Please ask for: Ms Iqraa Malik
Email: iqraa.malik@terraquest.co.uk
Telephone: 0121 234 1390
Our Ref: FP/251/21/PL
Your Ref:
Date: 22nd November 2021

Application for Planning Permission

Development: Erection of single storey rear extension following the demolition of existing lean to.
Location: 5 Davenport Road Felpham PO22 7JP

DATE	REVISION	BY
5 Davenport Road Felpham Bognor Regis West Sussex PO22 7JP		
DRAWN RD	CHECKED	
SCALE 1:50	DATE 06.01.22	
PROJECT TITLE Proposed Extension to 5 Davenport Road		
DRAWING TITLE Proposed Ground Floor Plan		
DWG NUMBER 009	REV	
NEG NUMBER

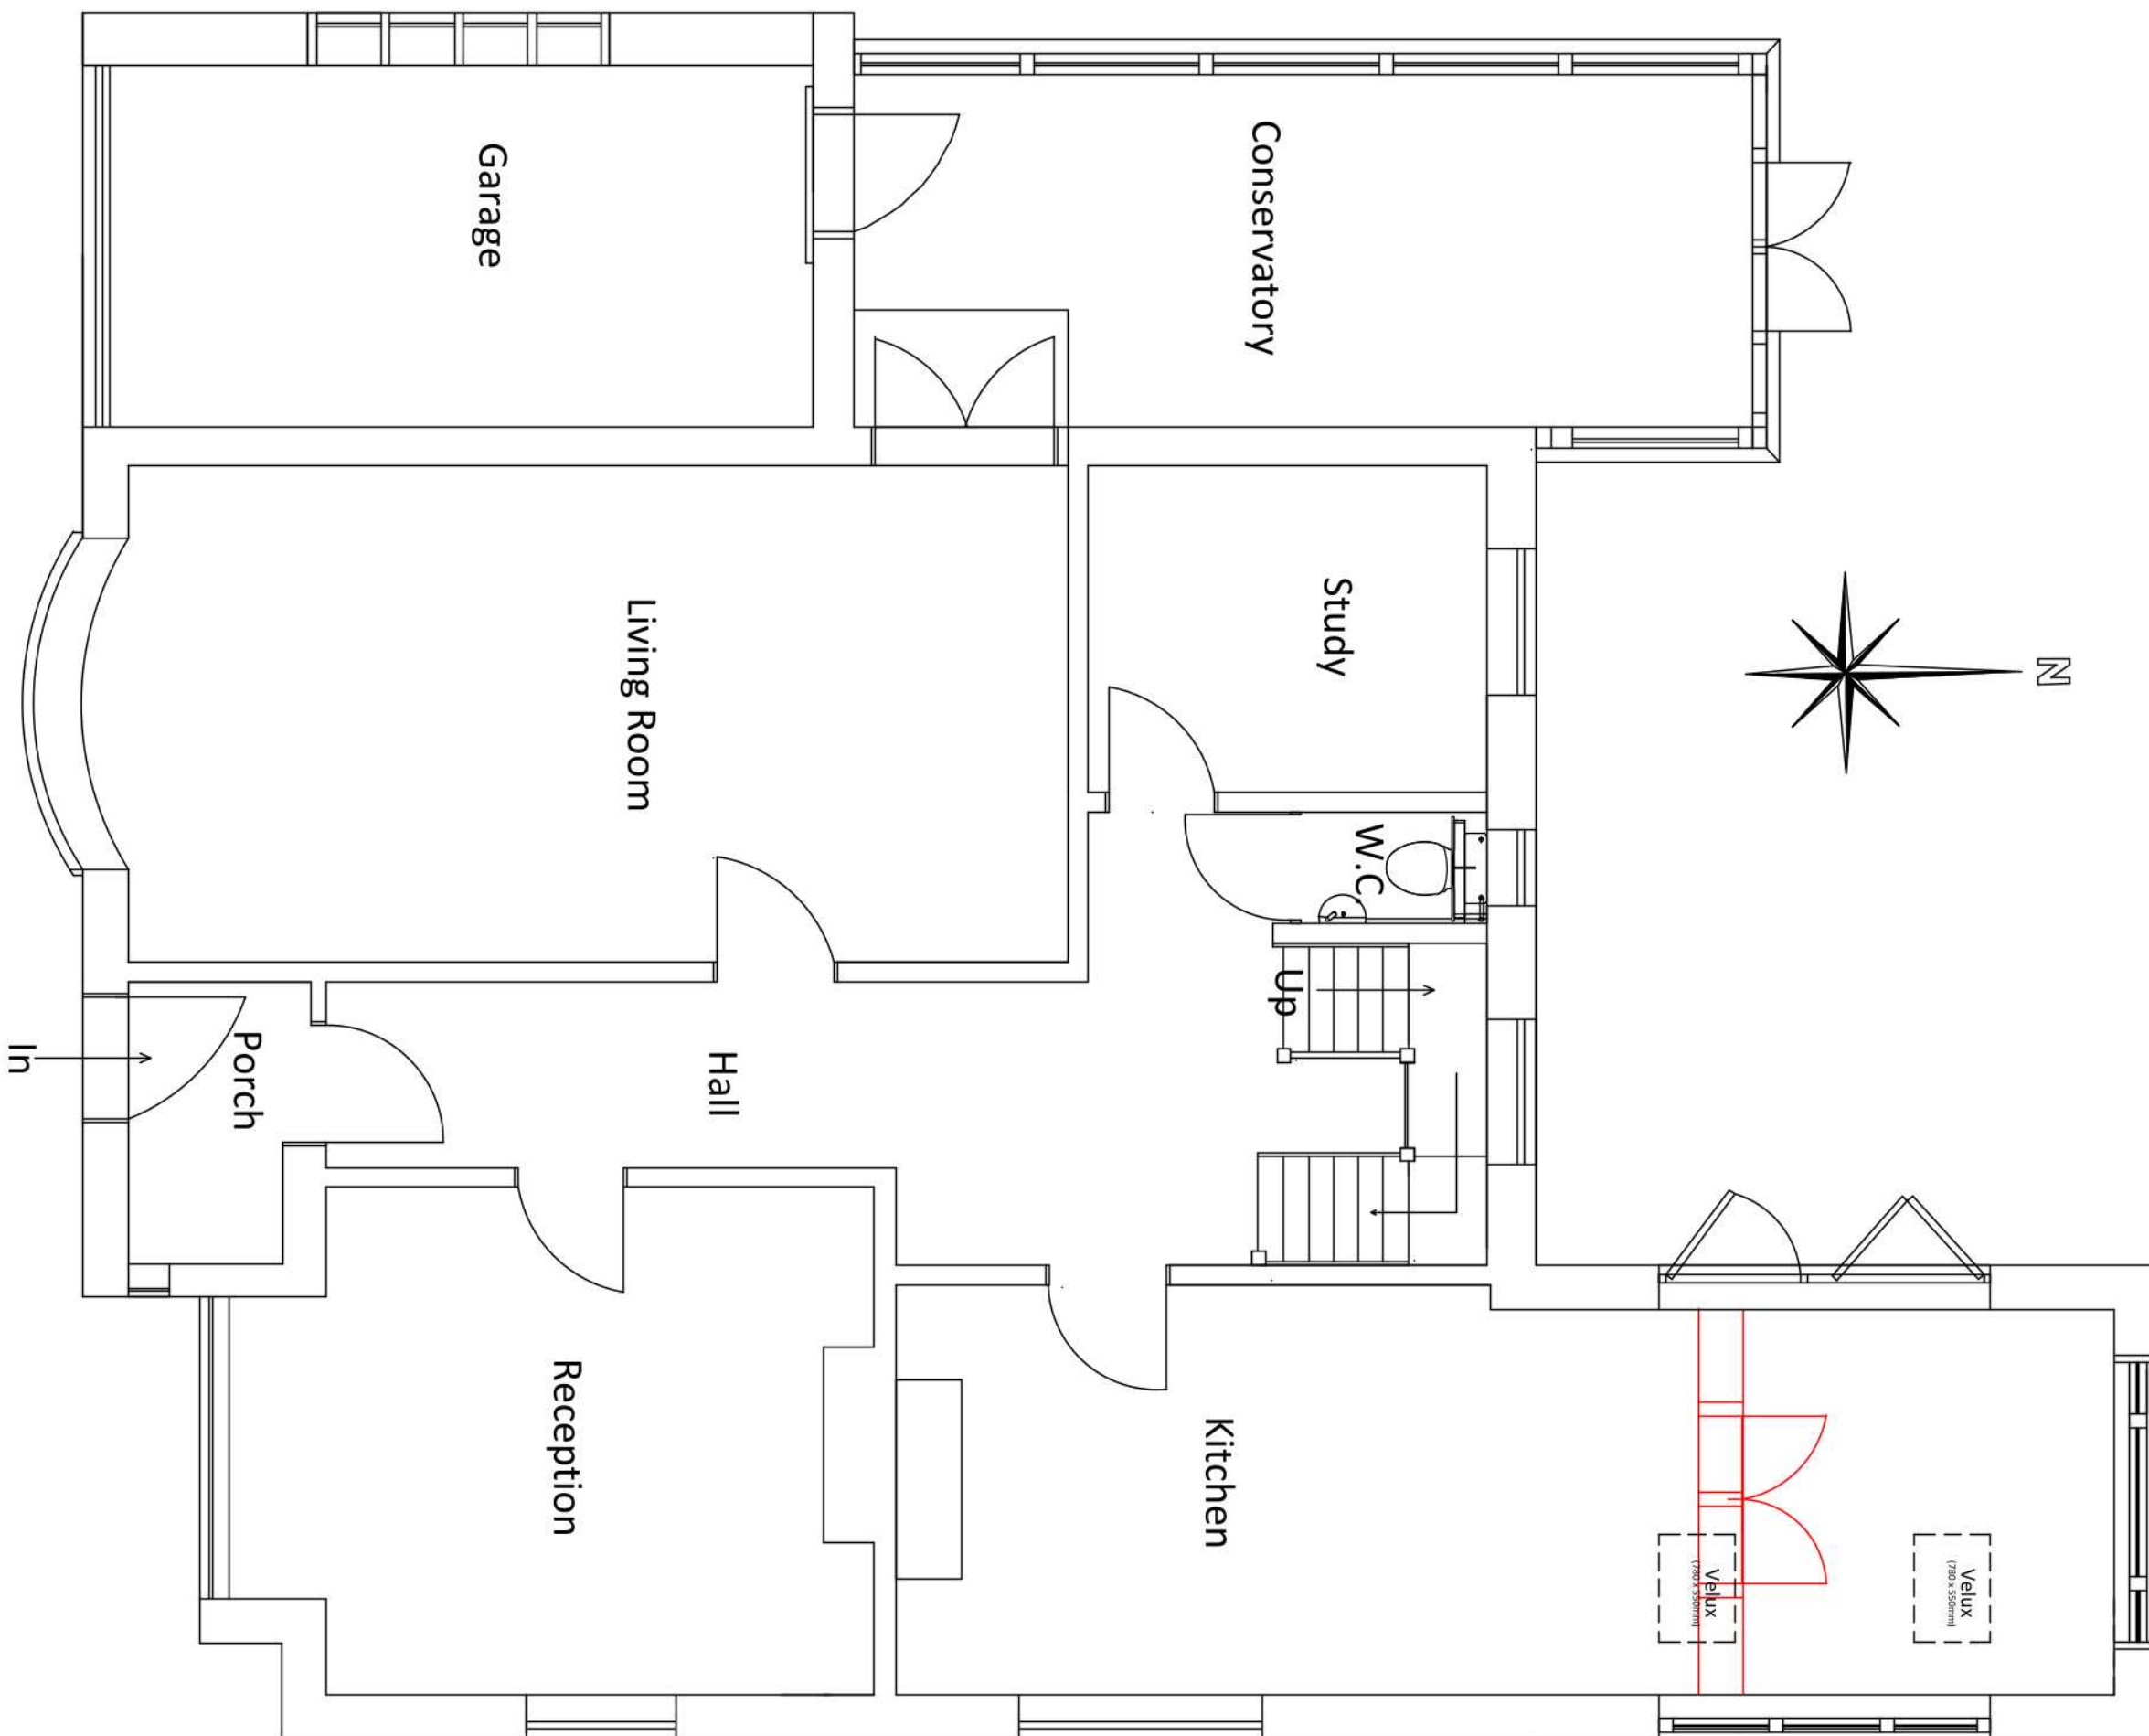
Please submit proposed elevations at a scale of 1:50 or 1:100. Along with this, the proposed floor plans require a stated scale. Further details can be found in the Validation Requirements List.
